February 16, 2023

Subject: SUB22-006 (Premium Homes of Mercer Island Preliminary Short Subdivision)
Request for Information #1

In response to the City of Mercer Island comment letter dated December 22, 2022, we have completed the revisions to SUB22-006 (Premium Homes of Mercer Island Preliminary Short Subdivision). The following is a description of the revisions.

# TREE RETENTION PLAN

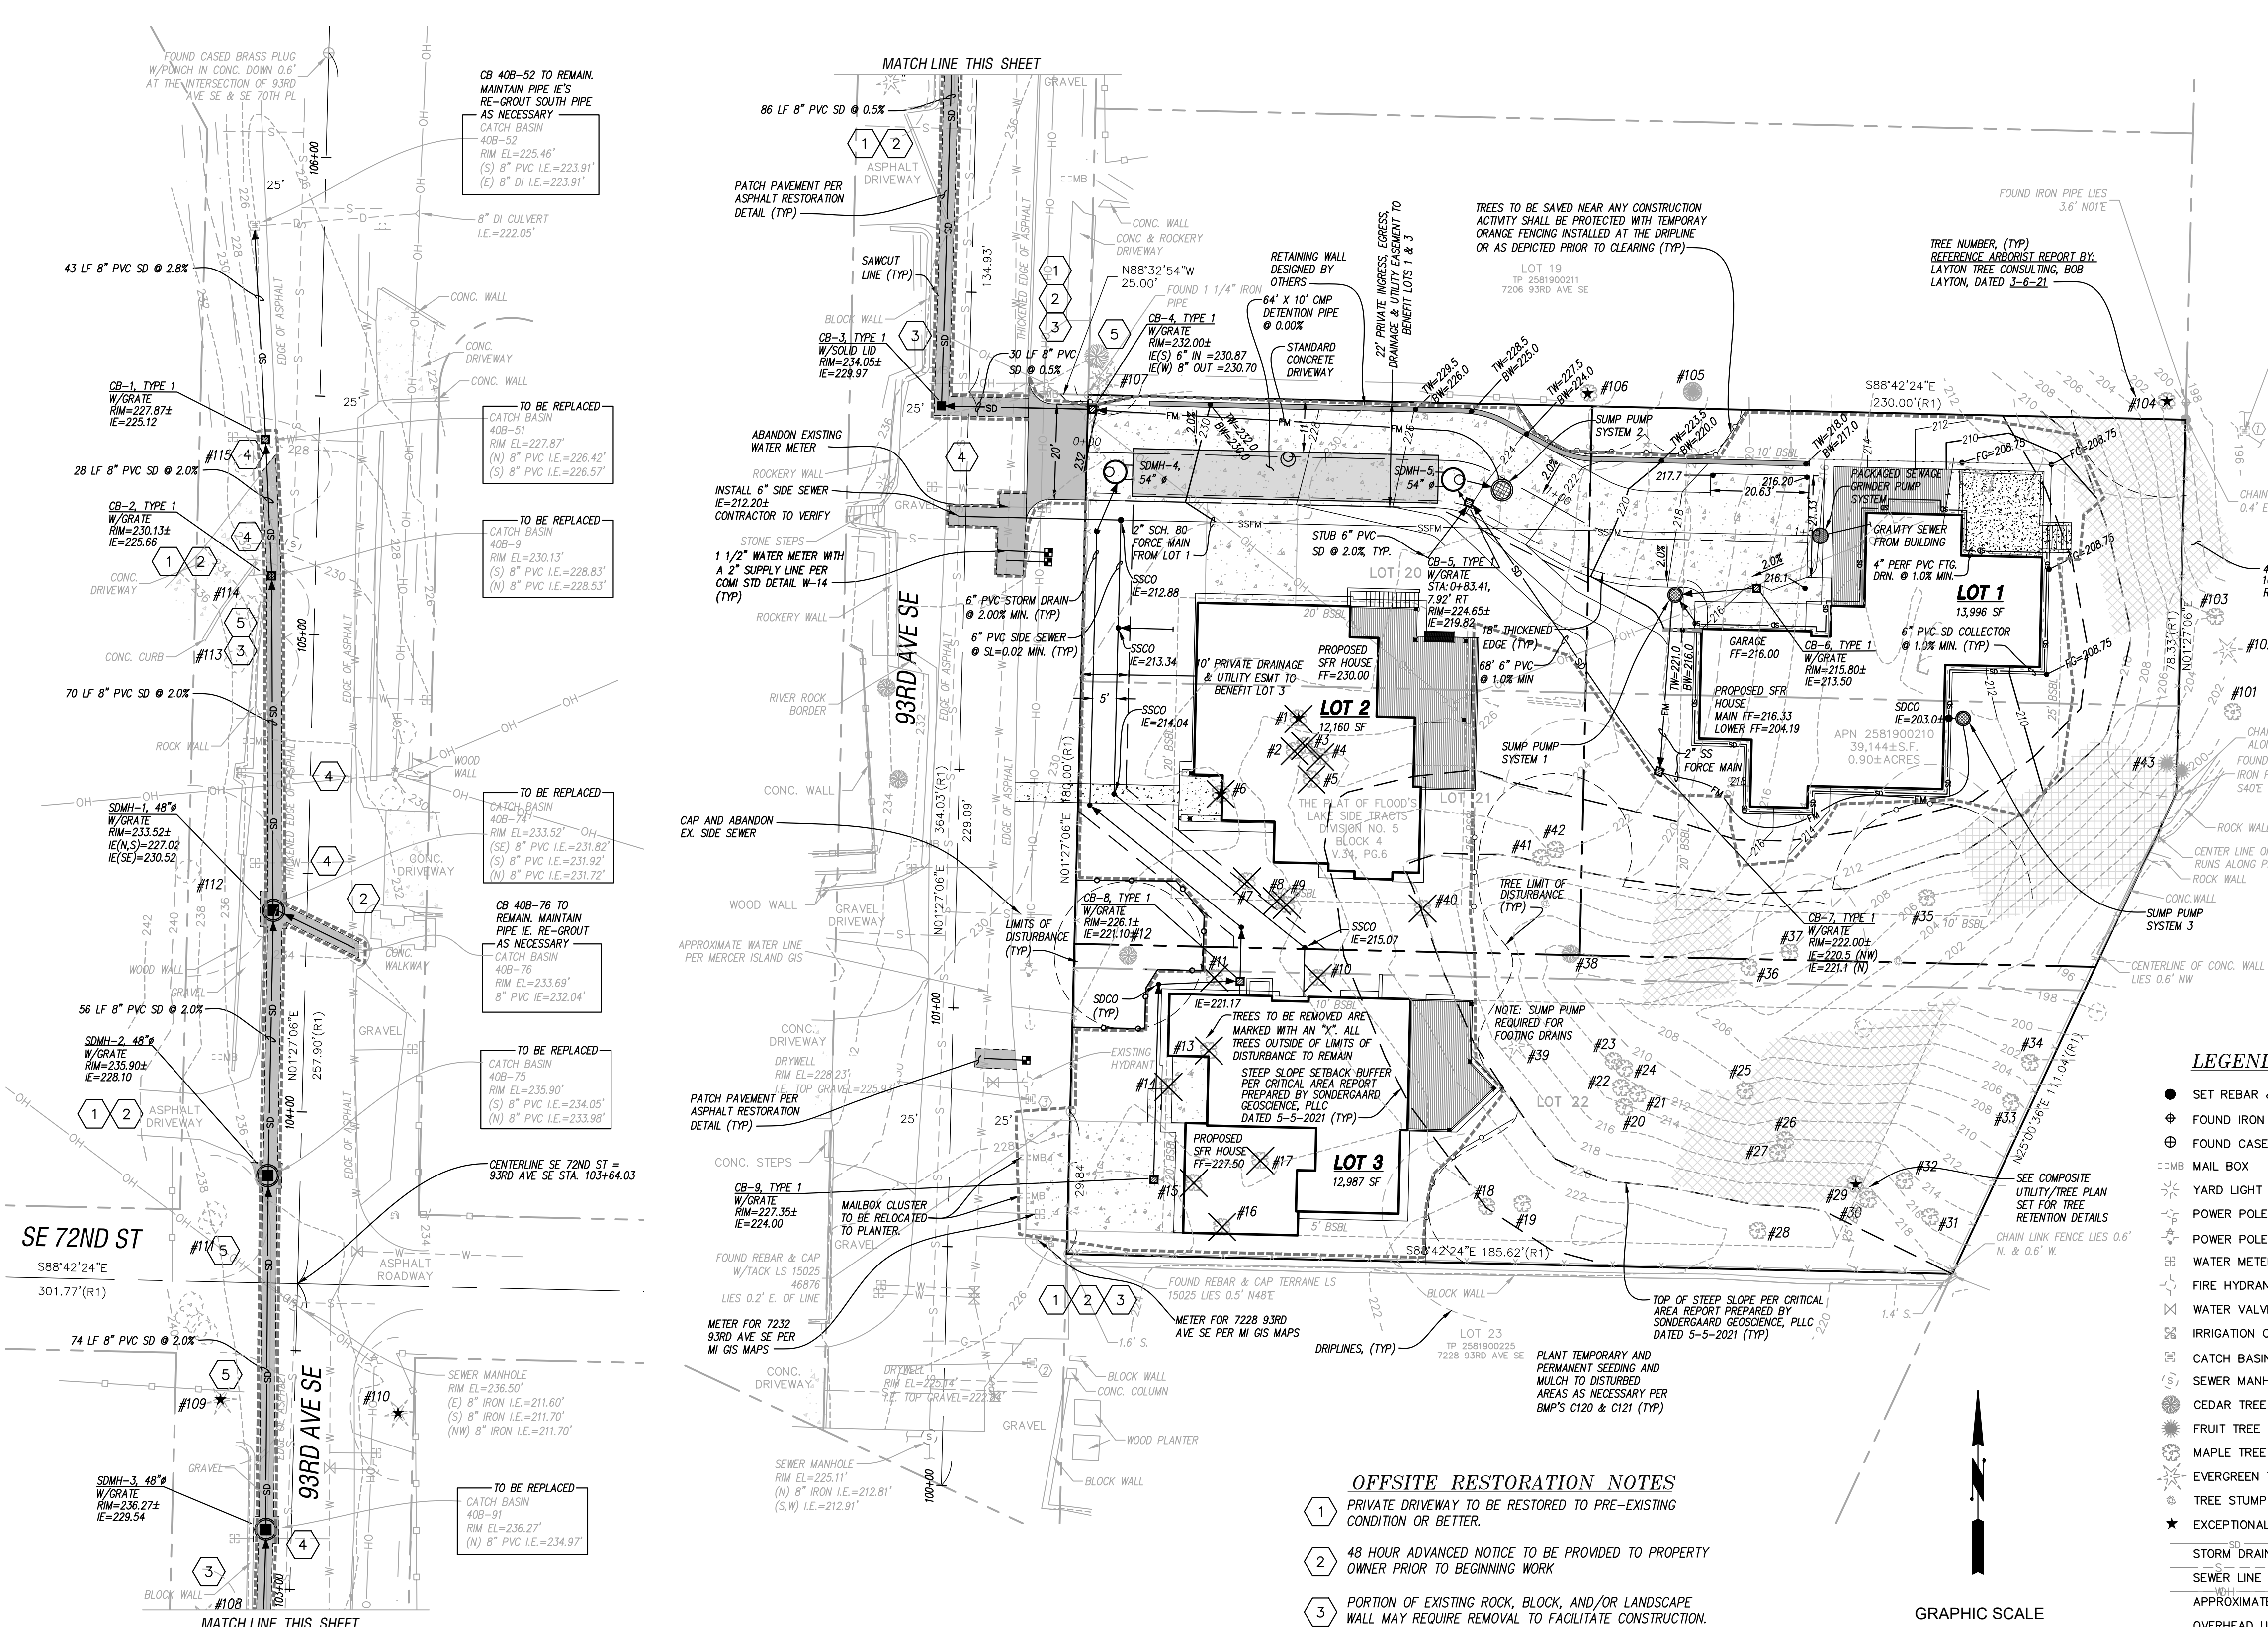
1. (For architect) Tree 12 appears to be an exceptional grove tree over 24 inches in diameter and would need to be retained and protected at its dripline as provided by the arborise. This would include moving the building pad and installing any utilities in the proposed

easement so they do not damage the tree. This would also include tunnel/bore trenchless technology or air excavation under Certified Arborist direction. Alternatively, the tree could be removed if you can justify the removal under MICC 19.10.060(A)(3).

Tree #12 will now be retained. The proposed private storm and sewer line in the vicinity of tree #12 have been revised per the tree protection recommendations provided in Bob Layton's Tree Memo included in the resubmittal. Refer to response letter prepared by McCullough Architects for additional information.
